# KIRKLEES METROPOLITAN COUNCIL INVESTMENT & REGENERATION SERVICE

| Reference No:         | 2024/62/93576/E                                                                             |
| Site Address:         | 32, Station Road, Shepley, Huddersfield, HD8 8DG                                            |
| Description:          | Erection of stone garden walls and timber gate (Listed Building within a Conservation Area) |

Drawing Title:
PLANS AS EXISTING & PROPOSED

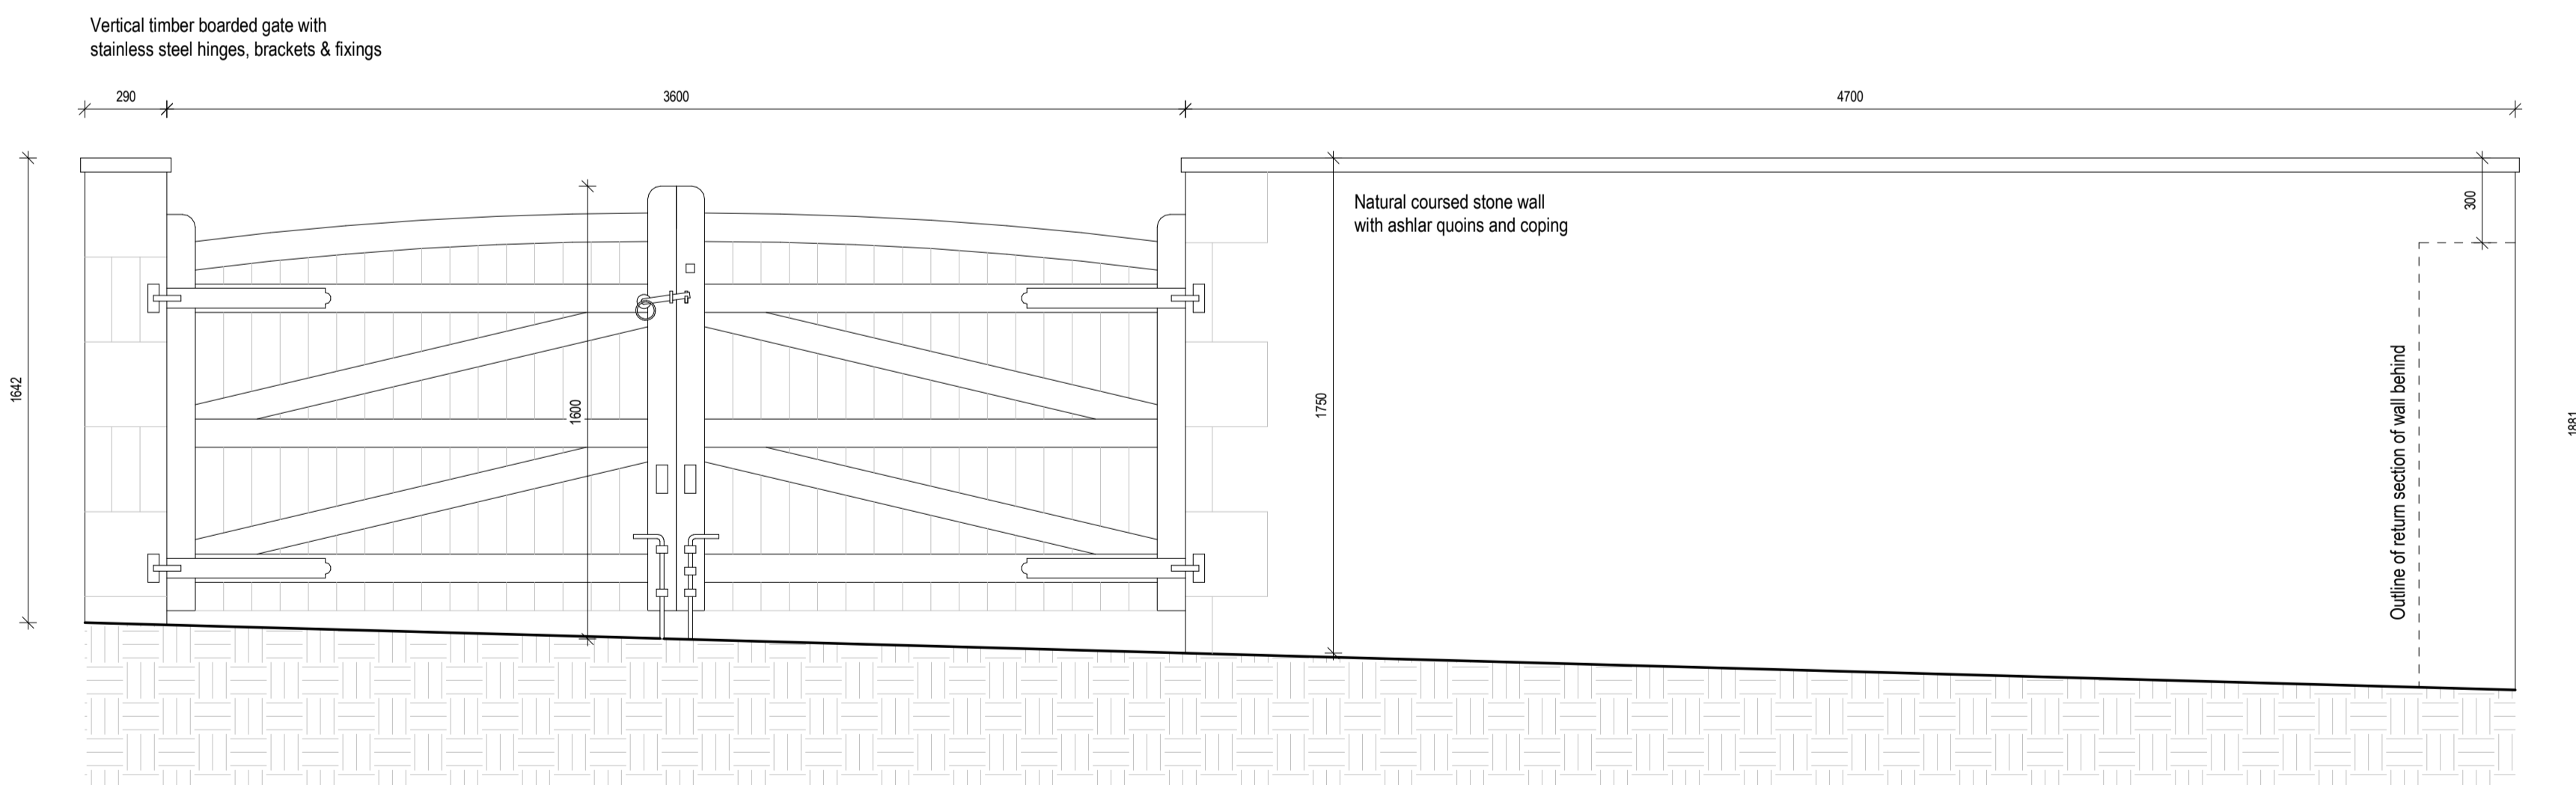
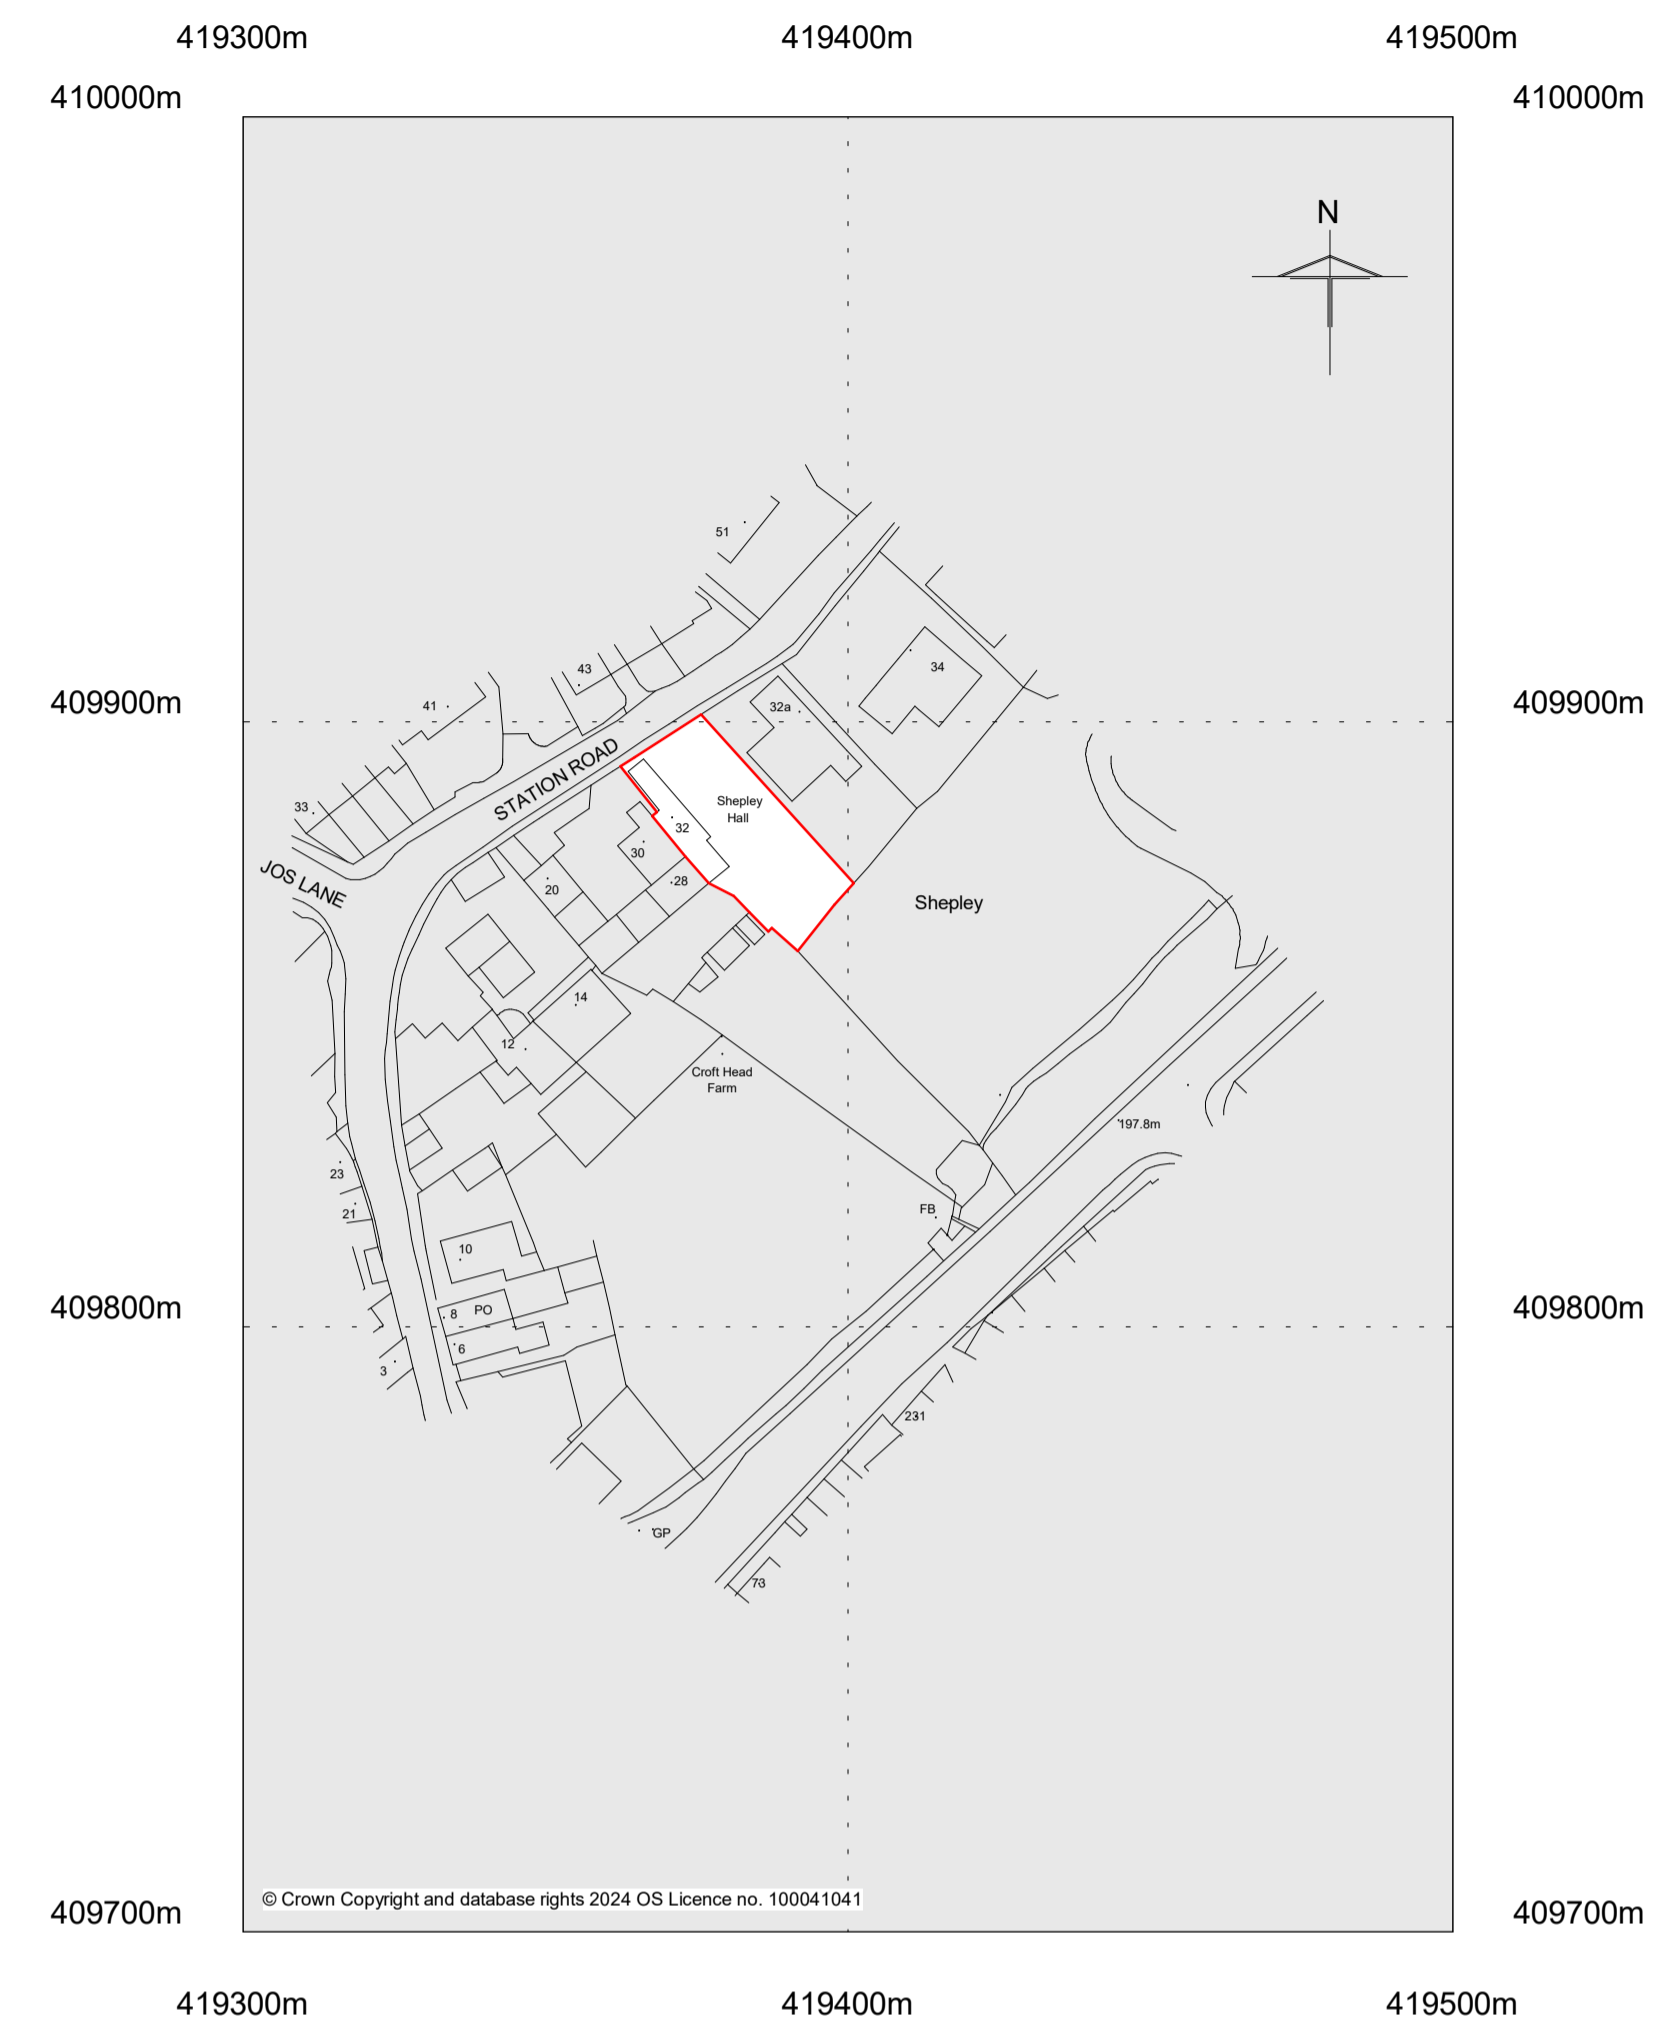
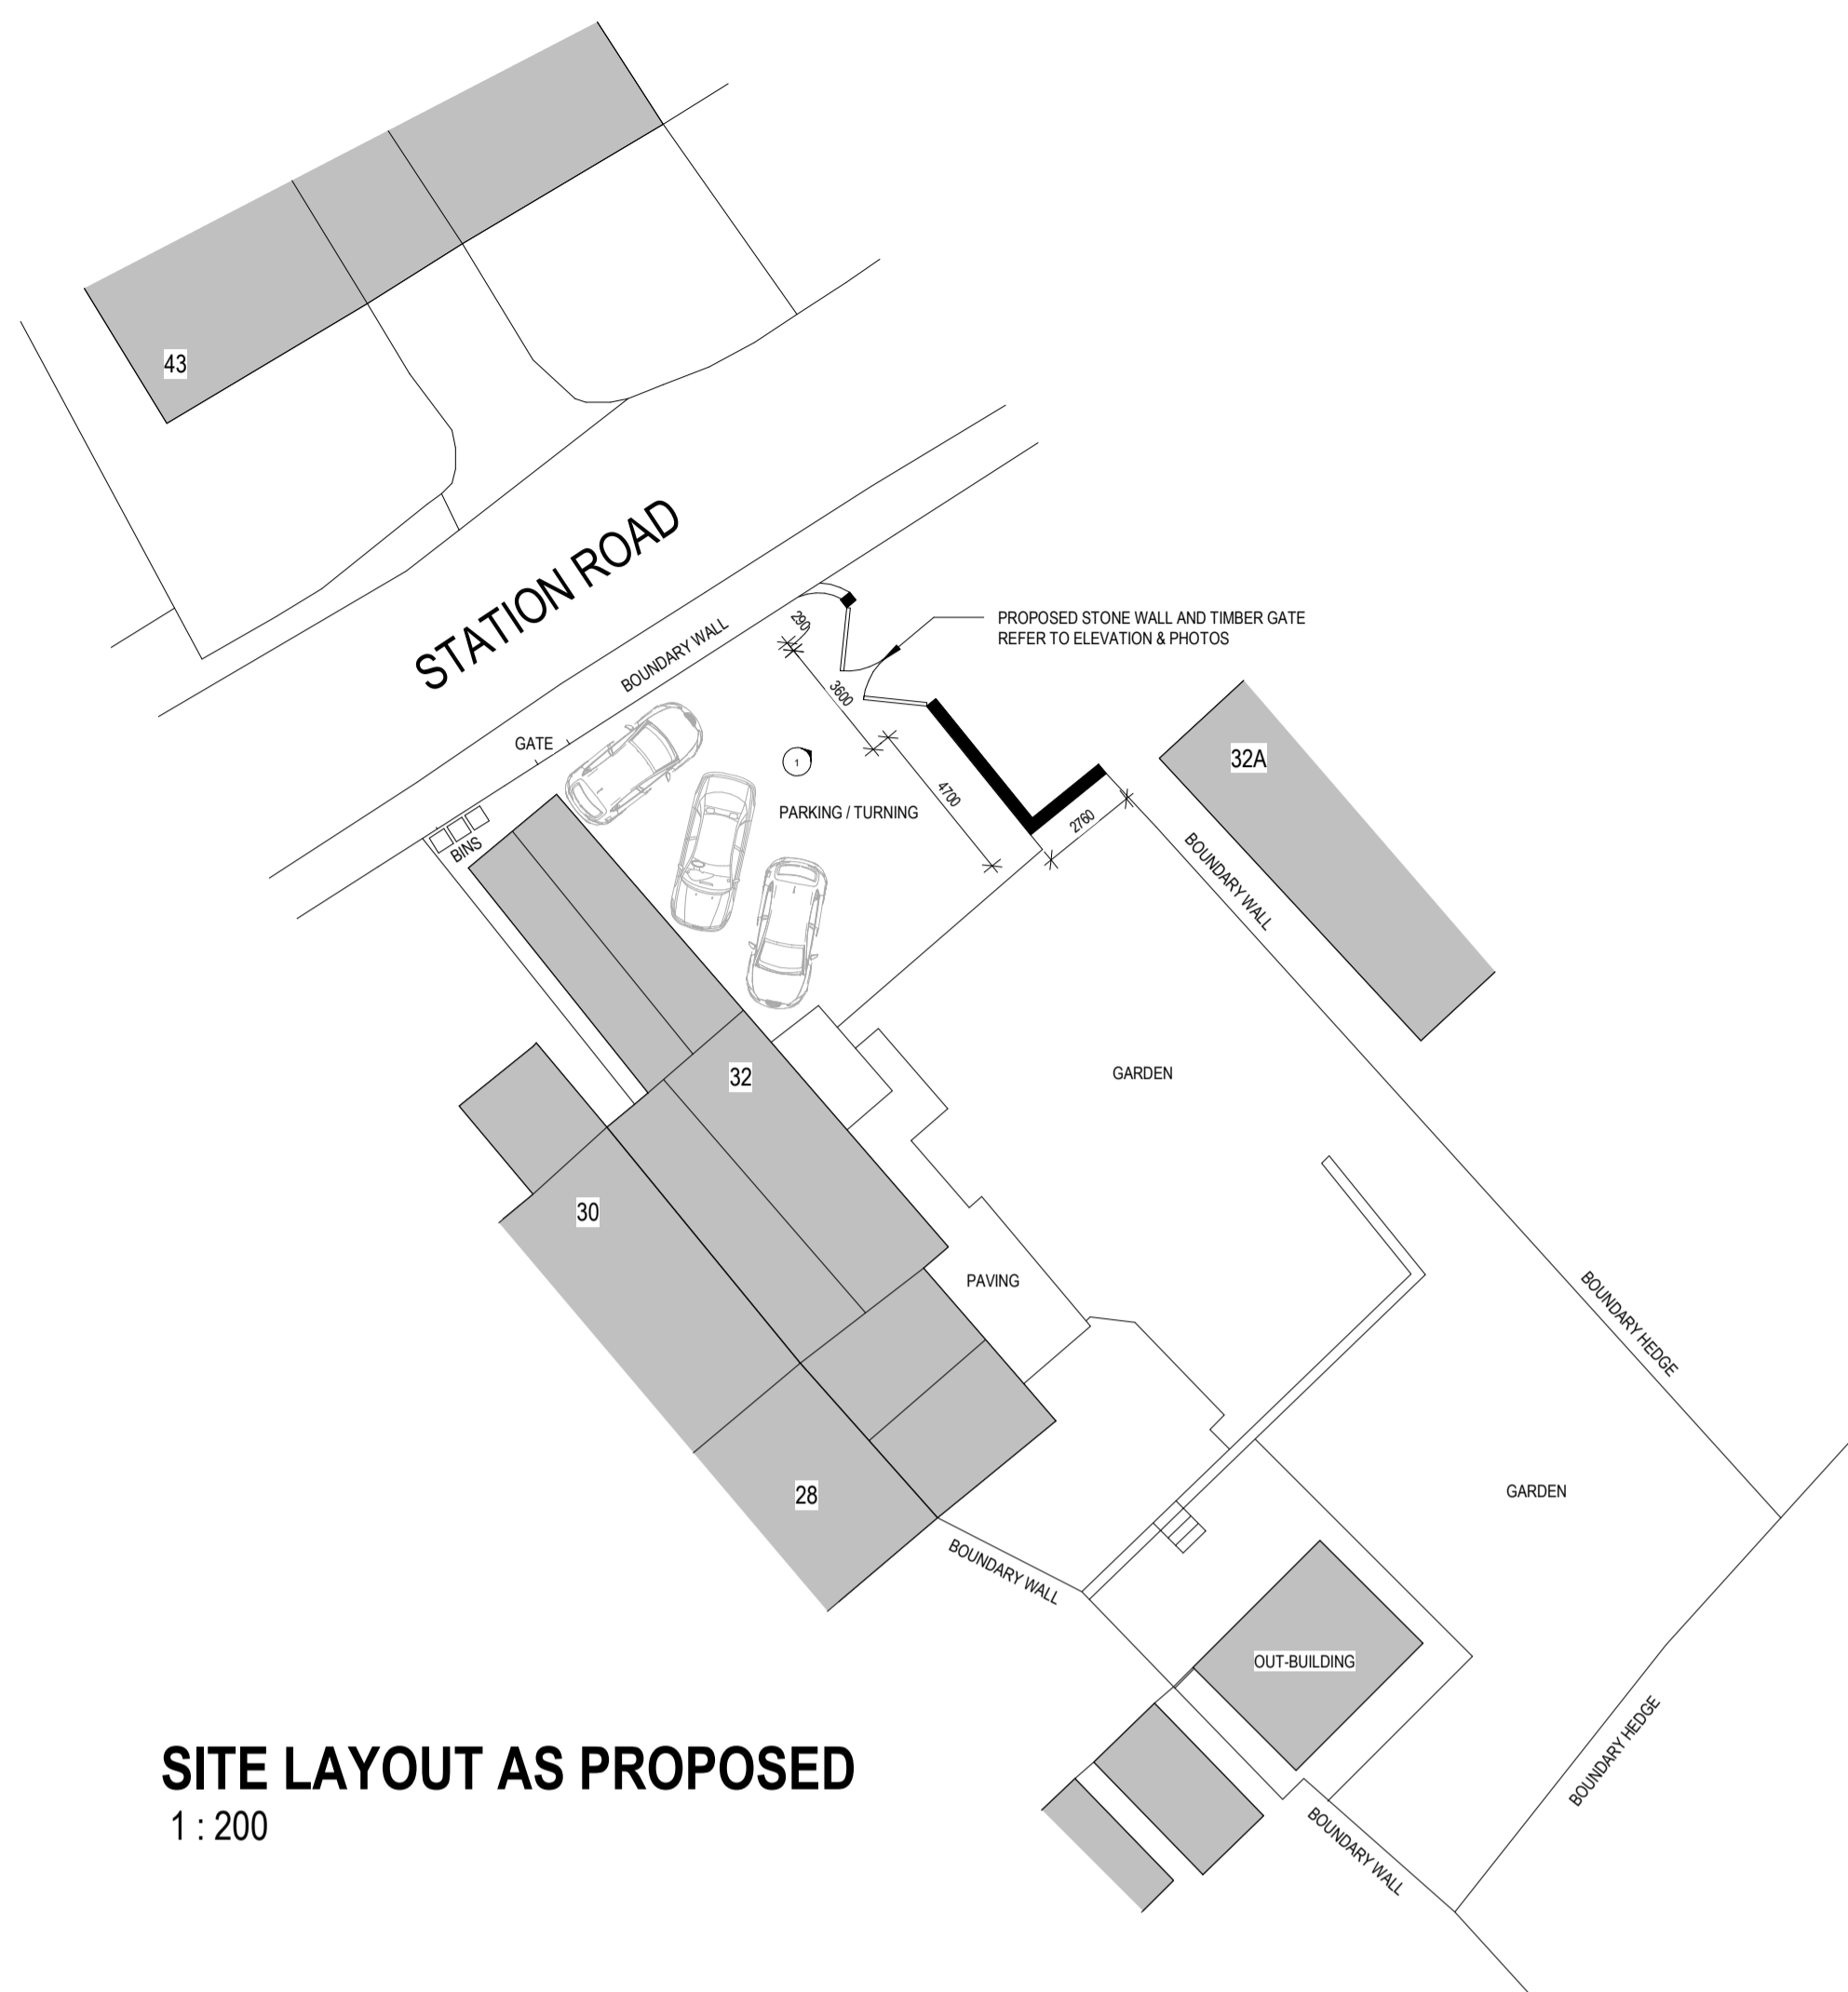
occupant. However, the wall is in a highly visible location from the street, and its construction style—including its height, stone size, and flat horizontal coping—does not complement the character of the listed building or the surrounding conservation area. Due to its design and scale, the walling and gate have a detrimental and negative effect on both the listed building and its setting. When considering harm, as set out by paragraph 212 of the NPPF, great weight should be given to the asset's conservation. Paragraph 213 goes on to state that any harm should require clear and convincing justification. The development results in less than substantial harm which will be weighed against the public benefits of the proposal. While paragraphs 4.6, 4.7, and 6.04 of the statement highlight security benefits for the applicant, these considerations do not constitute a public benefit or provide sufficient justification for the harm caused to the listed building and conservation area. As such the development proposals would result in harm to the character and setting of the listed building and conservation area contrary to Local Plan Policy LP35 and Chapter 16 of the NPPF.

The wall is prominently visible from the street, and its construction style—including its height, stone size, and flat horizontal coping—does not harmonize with the character of the listed building or the surrounding conservation area. Consequently, due to its design and scale, the works have a detrimental impact on both the listed building and its setting which are intrinsic in terms of the character of the area and visual amenity. Therefore, the walling and gate are not considered acceptable in terms of visual amenity.

The walling and gate, given the prominent position together with the construction style, height, stone size and use of flat, horizontal coping does not harmonise with the character of the listed building or the surrounding conservation area and as such has a negative impact on the heritage asset and visual amenity. To permit the proposals would be contrary to Policies LP24 & LP35 of the Kirklees Local Plan, KDP1 of the House Extensions & Alterations SPD along with Chapters 12 & 16 of the National planning Policy Framework.

1. Due to the height, method of construction, materials, including stone size and use of flat, horizontal coping, as well as the prominent position, the walling and gate do not harmonise with the character of the listed building or the surrounding conservation area detracting from the character of the host building, its setting and designated heritage assets. To permit the proposals would be contrary to Policies LP24 & LP35 of the Kirklees Local Plan, KDP1 of the House Extensions & Alterations SPD along with Chapters 12 & 16 of the National planning Policy Framework.
